Thomas Piovesan
Planning and Assessment Group
NSW Department of Planning, Industry and Environment

**Eastern Creek retail outlet centre (SSD-10457) -
Response to Submissions**

Detailed advice to DPIE Planning & Assessment regarding the Eastern Creek retail outlet centre (SSD-10457) – Response to Submissions

Henry and Hymas Earthworks Drawings

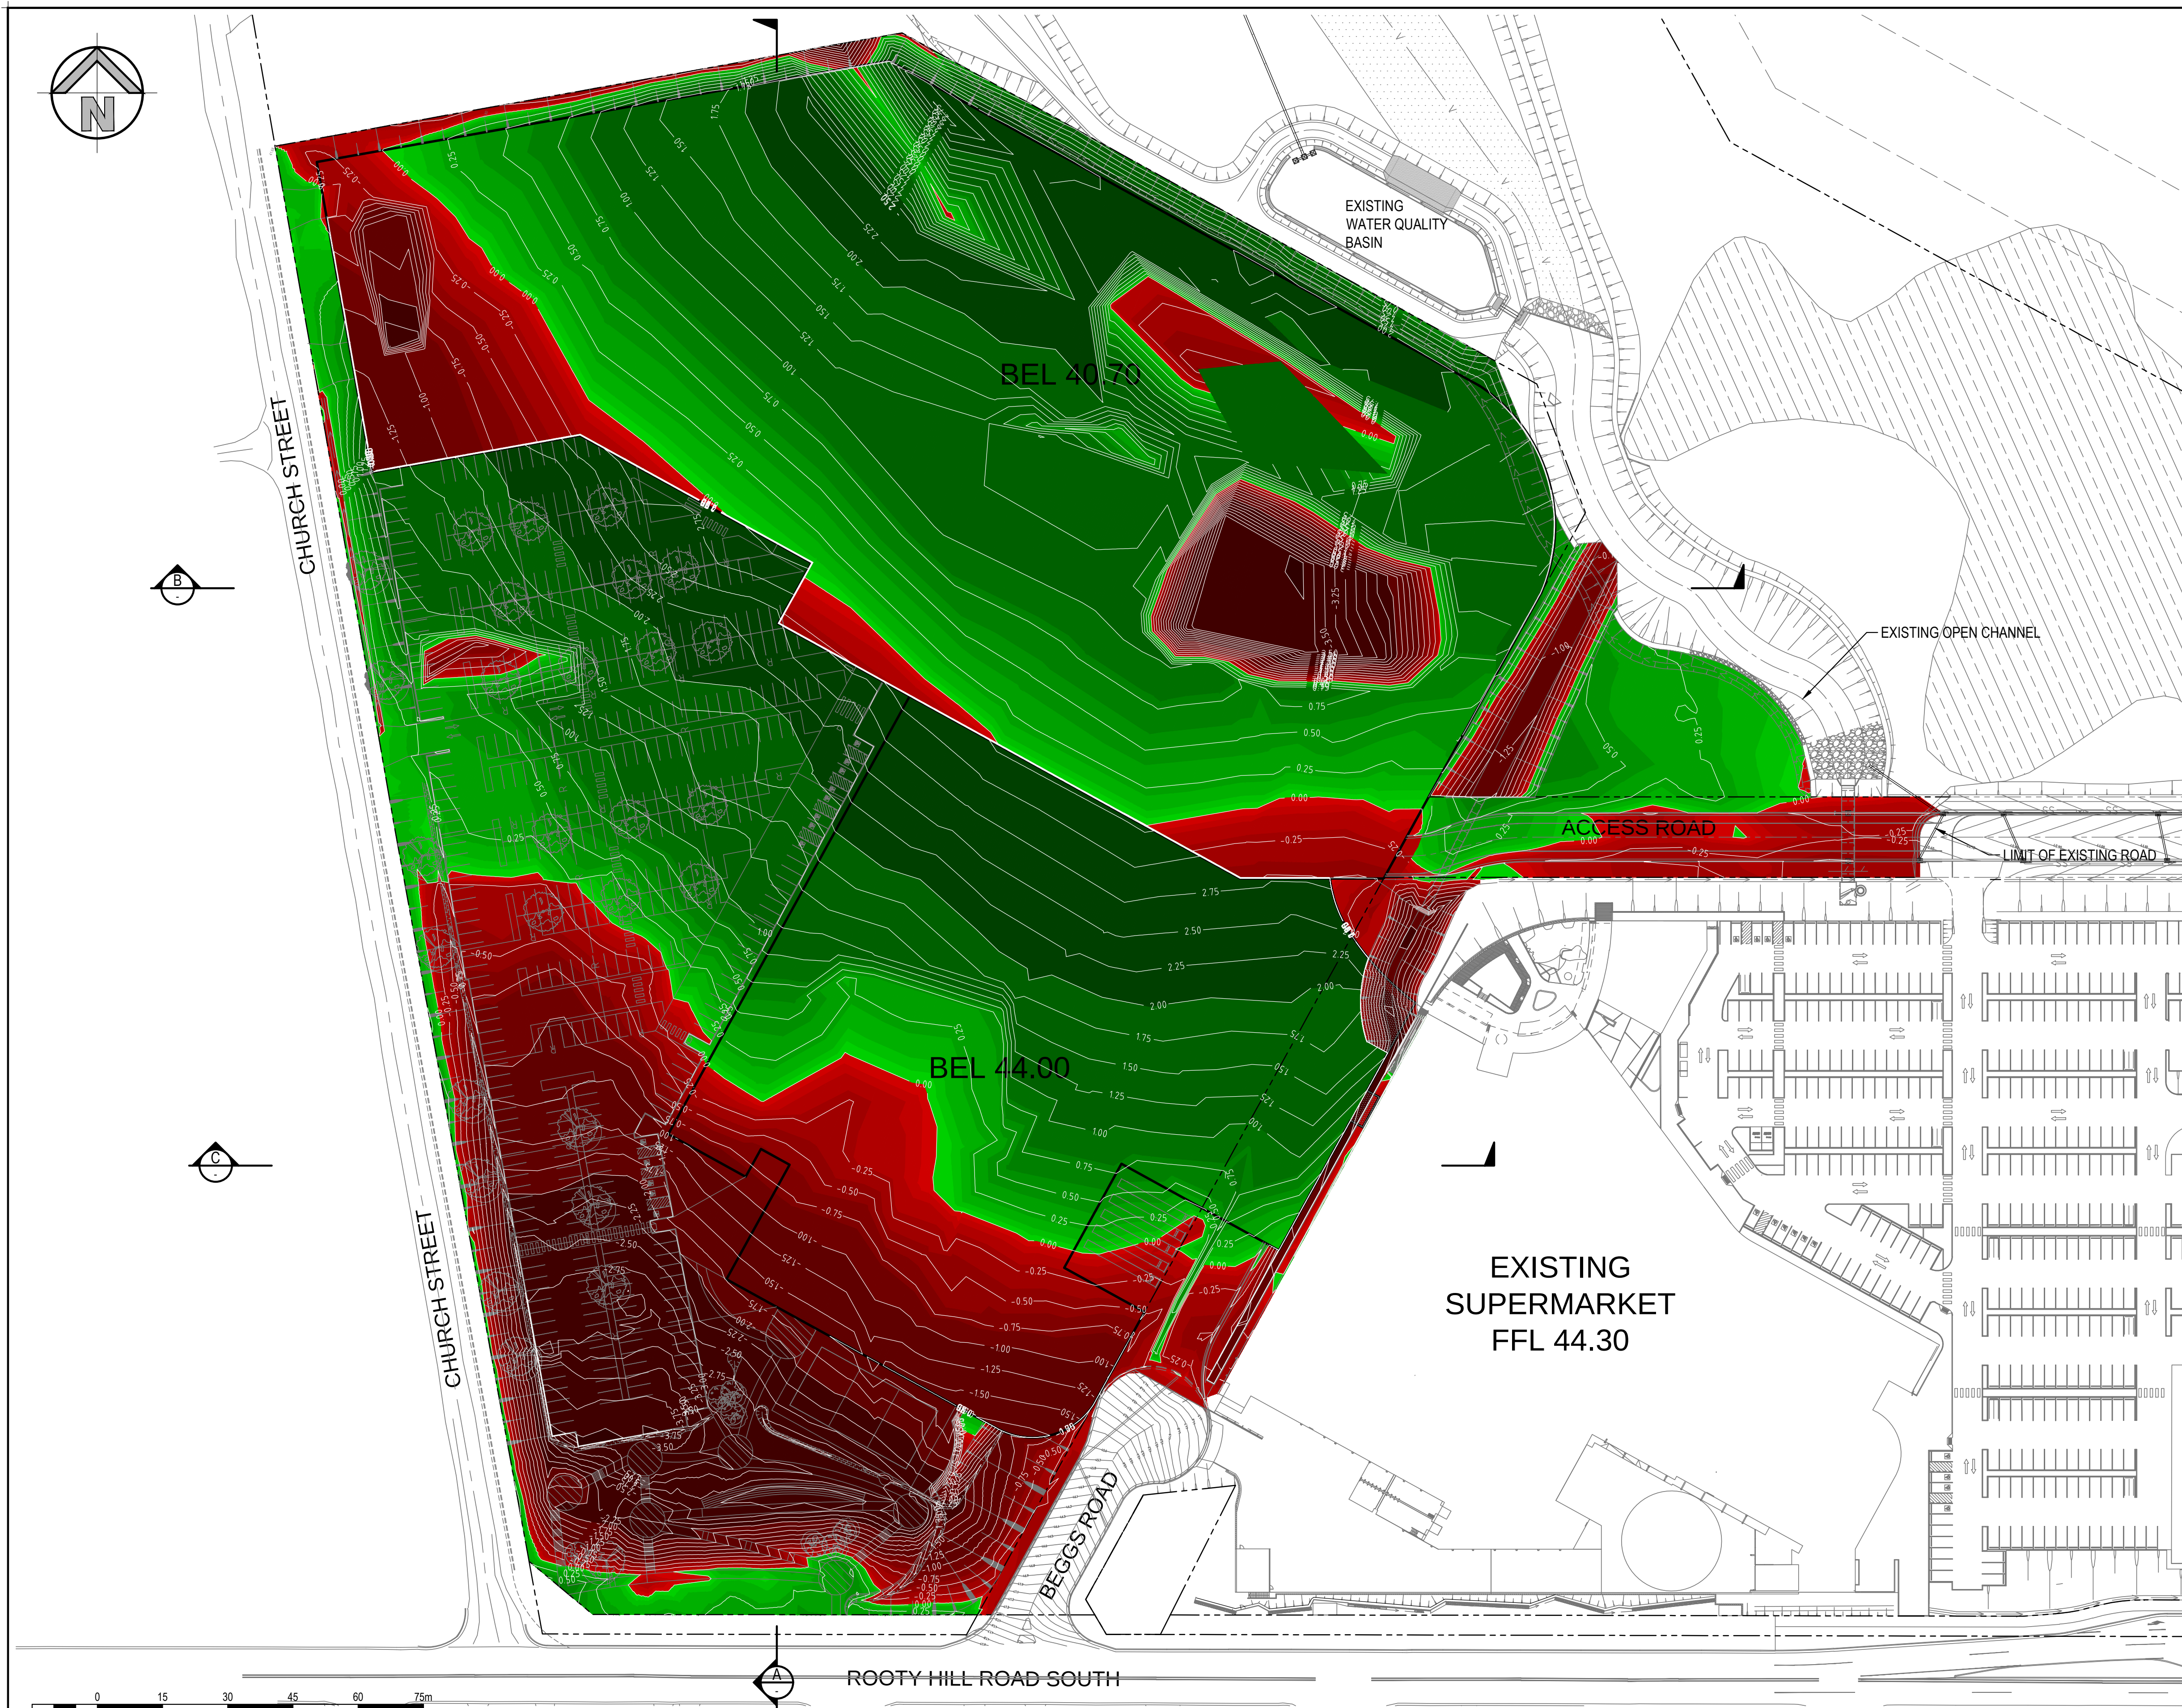
Given that the cut depths proposed for building pads and surface water management devices appear to be above previously documented water levels, it is unlikely that works will intercept the water table and hence be considered an aquifer interference activity for the purpose of assessment against minimal impact considerations of the NSW Aquifer Interference Policy. However, this position should be supported by an onsite assessment by the proponent.

For any surface water control device, such as additional culverts or sediment ponds, that haven't been determined under previous site wide consents (cut depths are greater than previously proposed), the DPIE Water recommends a minimum of 1 m separation between the bottom of any control device and the seasonal high groundwater level. Alternatively, an impermeable liner may be used where a separation distance of 1 m can't be achieved.
